7<sup>th</sup> March 2021

**LORETO NORMANHURST SCHOOL REDEVELOPMENT (CONCEPT PROPOSAL AND STAGE 1),  
91-93 PENNANT HILLS ROAD NORMANHURST (SSD-8996) – OBJECTION**

Drawing Title  
VIEW IMPACT ANALYSIS

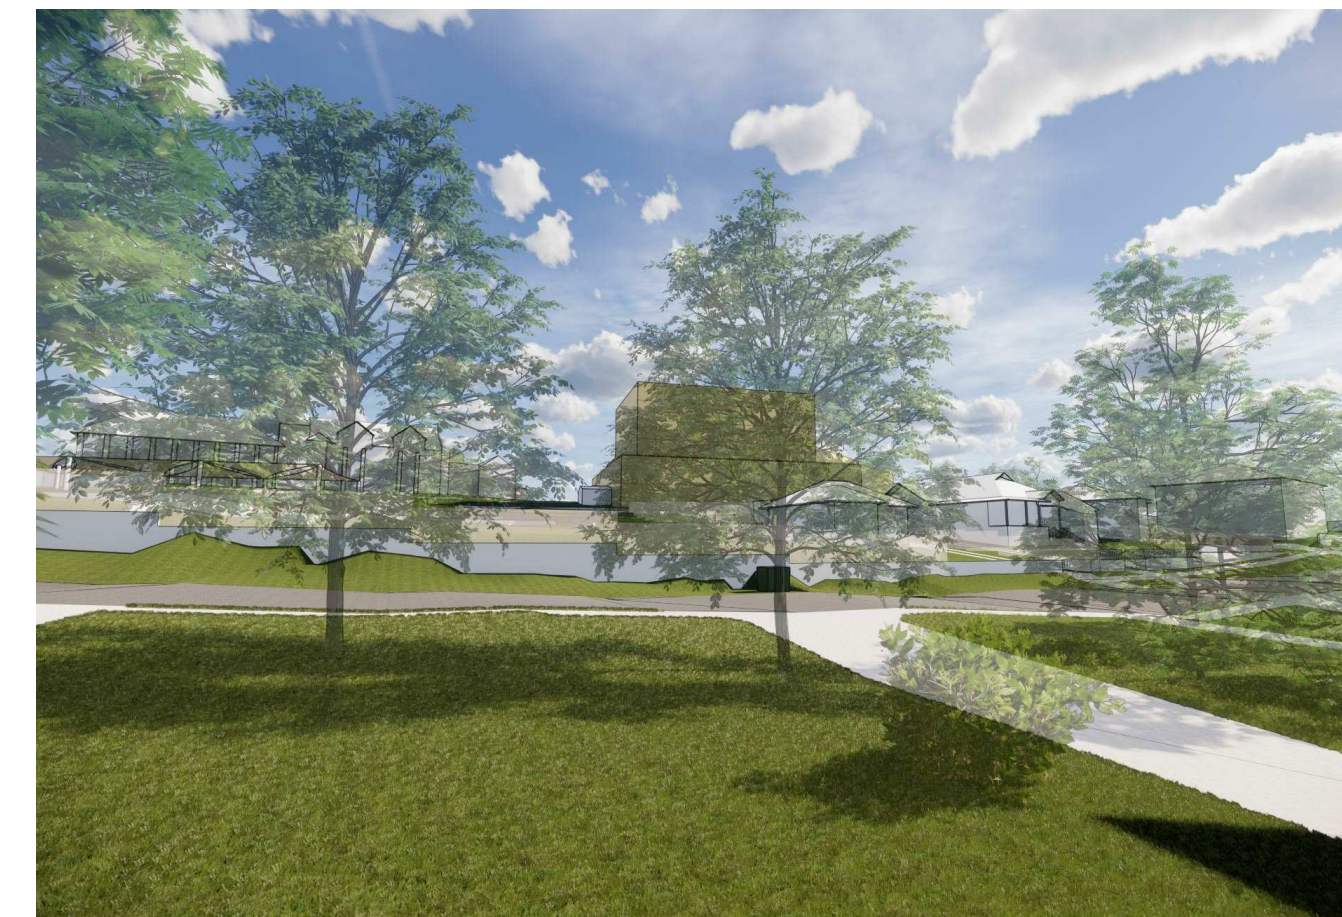
The images show almost no cars parked in Mount Pleasant Ave. This presents an unrealistic viewpoint. They also, for the most part, do not show fences.
